DEVELOPMENT CONSENT ORDER EN010012 : THE SIZEWELL C PROJECT

29 September 2021

ADDITIONAL SUBMISSION RE: ISSUE SPECIFIC HEARING 12 – SESSION 3 Section 4 ii re: BRIDLEWAY 19 LEISTON CUM SIZEWELL

DRAWING TITLE:
 CONSTRUCTION PHASE

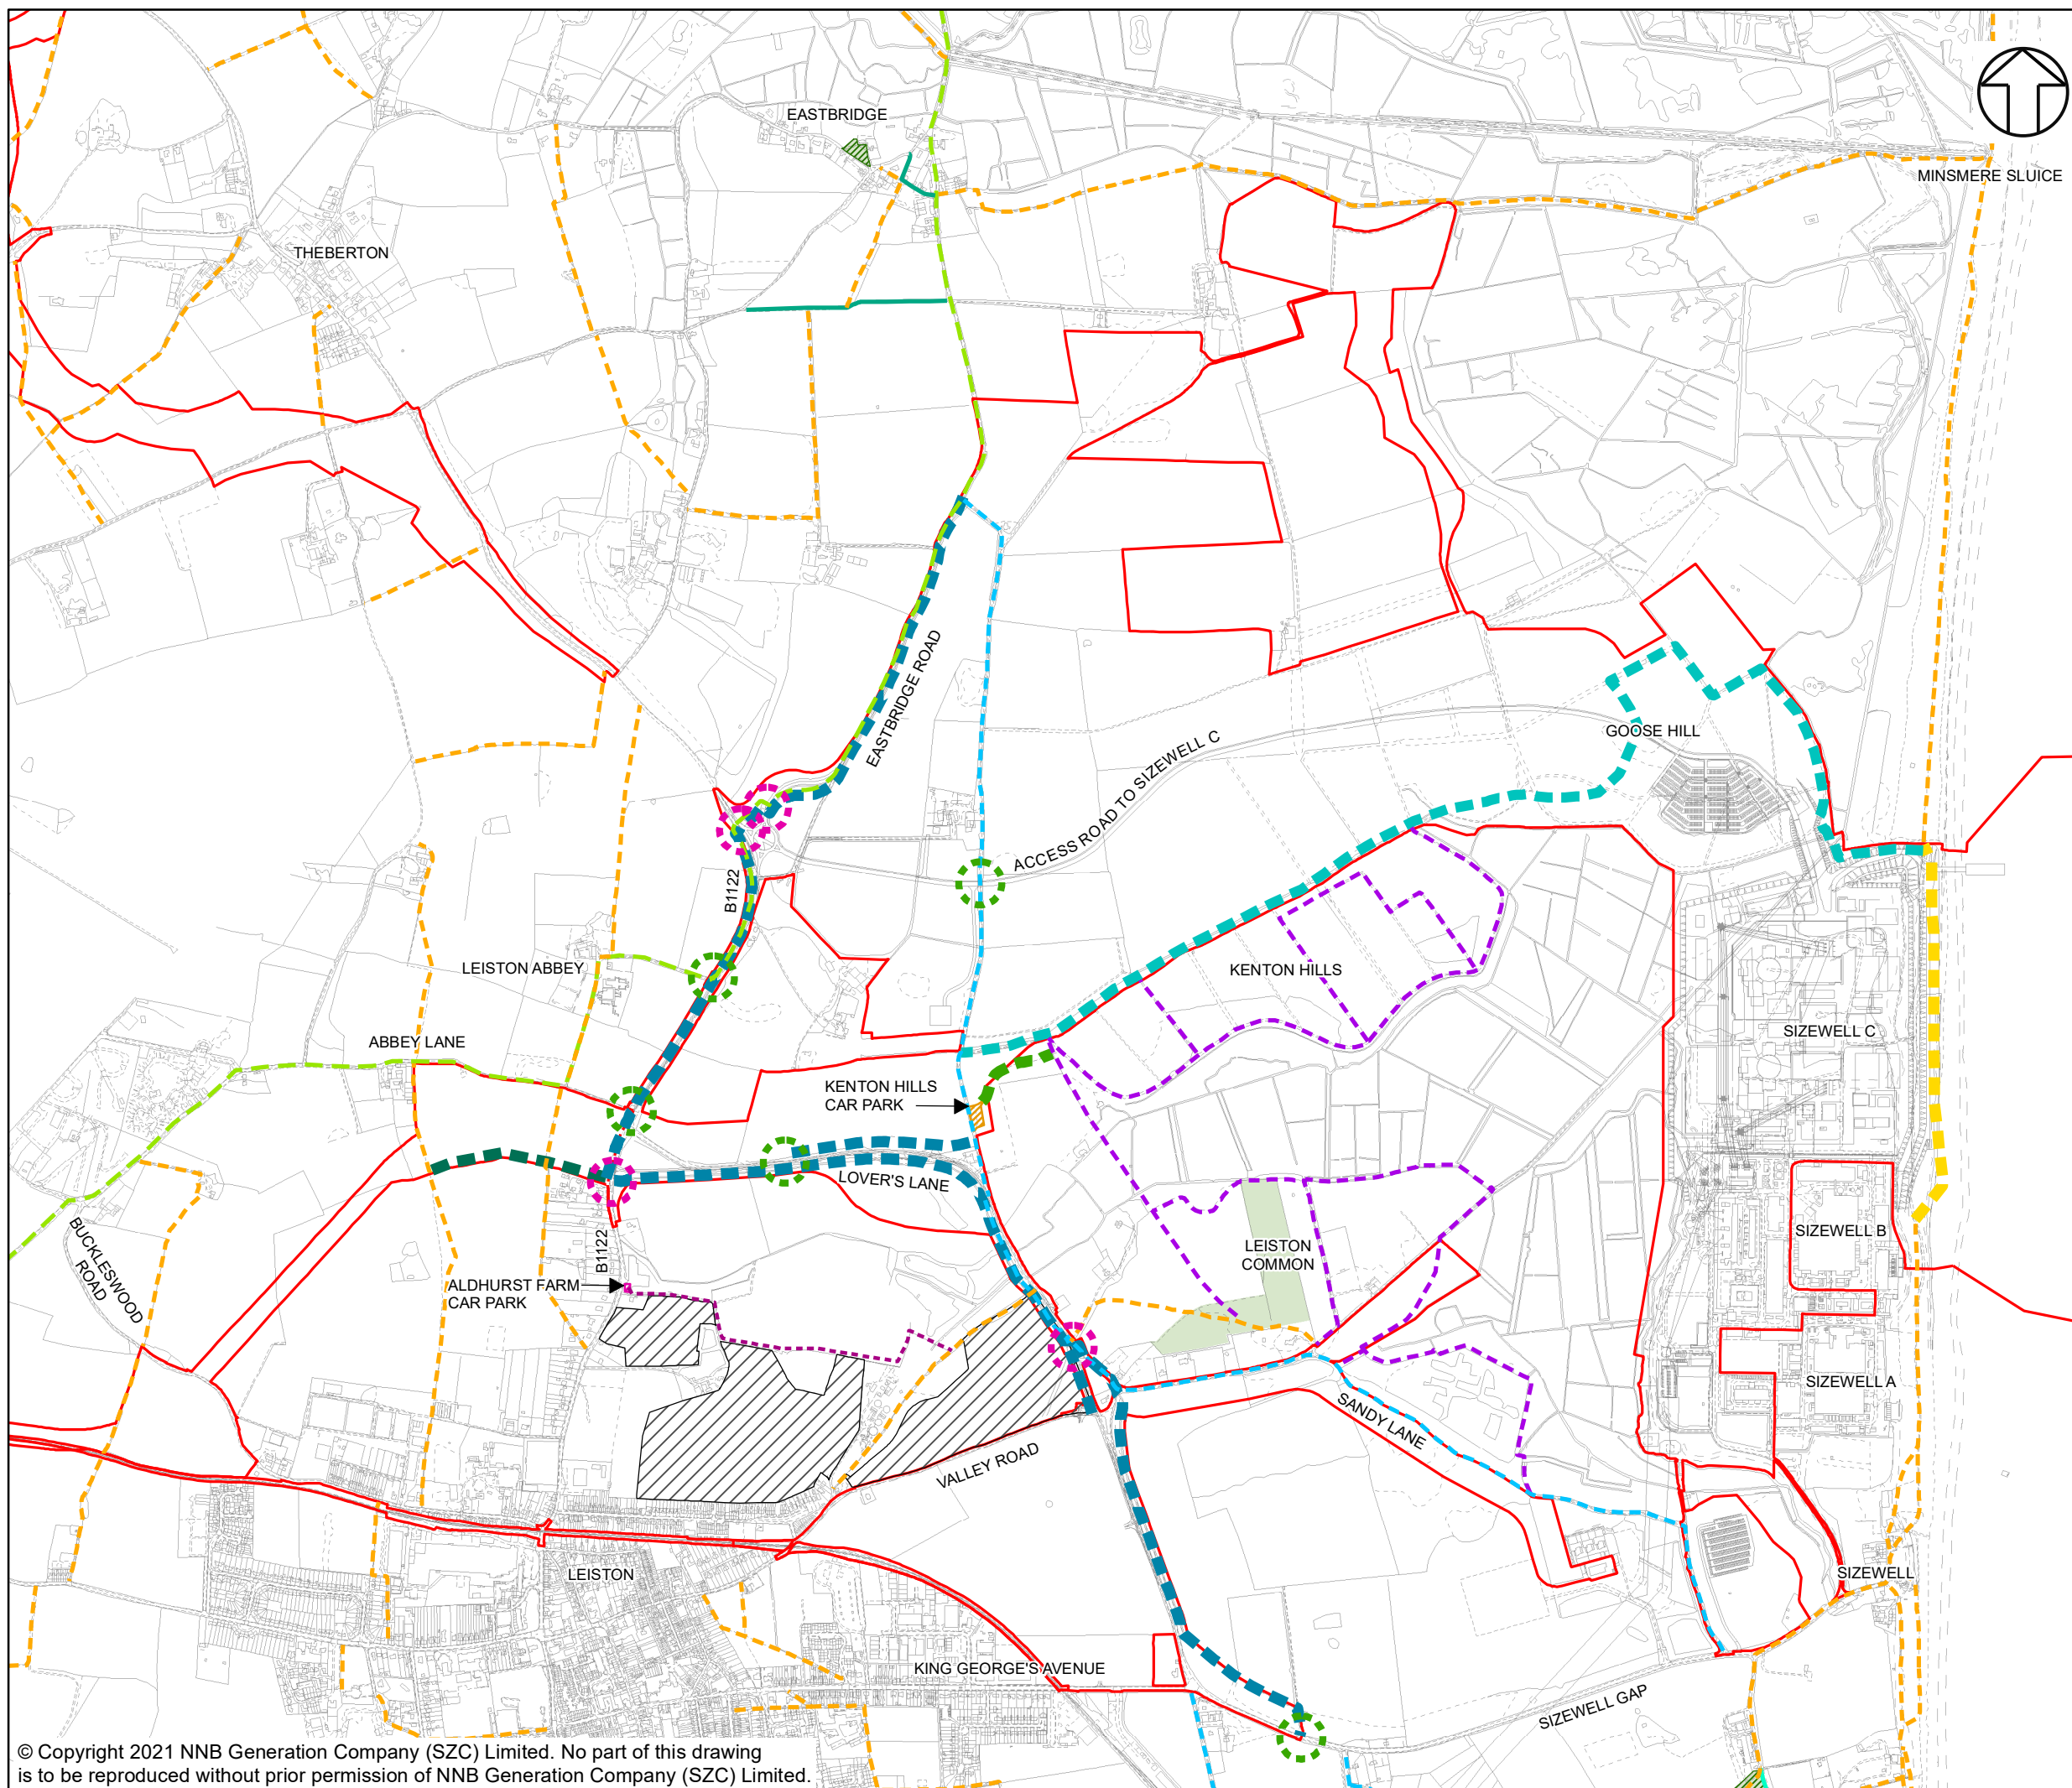
Below is an enlarged clip from Figure 15I.2 of the Main Development Site Environmental Statement: Rights of Way and Access Strategy ([REP8 055](#))

BR19 is shown as a pale blue line and the legend notes: route closed during construction.

Without local knowledge it is not clear to anyone viewing this rights of way plan that the grey detail of the background mapping is the proposed location of the secondary access to the main construction site from the vehicular highway yet to be authorised as shown in [REP8-023](#). **BR19** is compromised in at least three locations, as ringed in blue, by the internal access roadways and the proposed construction site railway of the proposed development site.

As can be seen from Diagrams 1, 2 and 3 above, **BR19** will be immediately compromised by the proposed works within the main construction site. It is totally unacceptable that horse riders, cyclists and pedestrians should be expected to use this route at any time during the proposed construction period. There will be
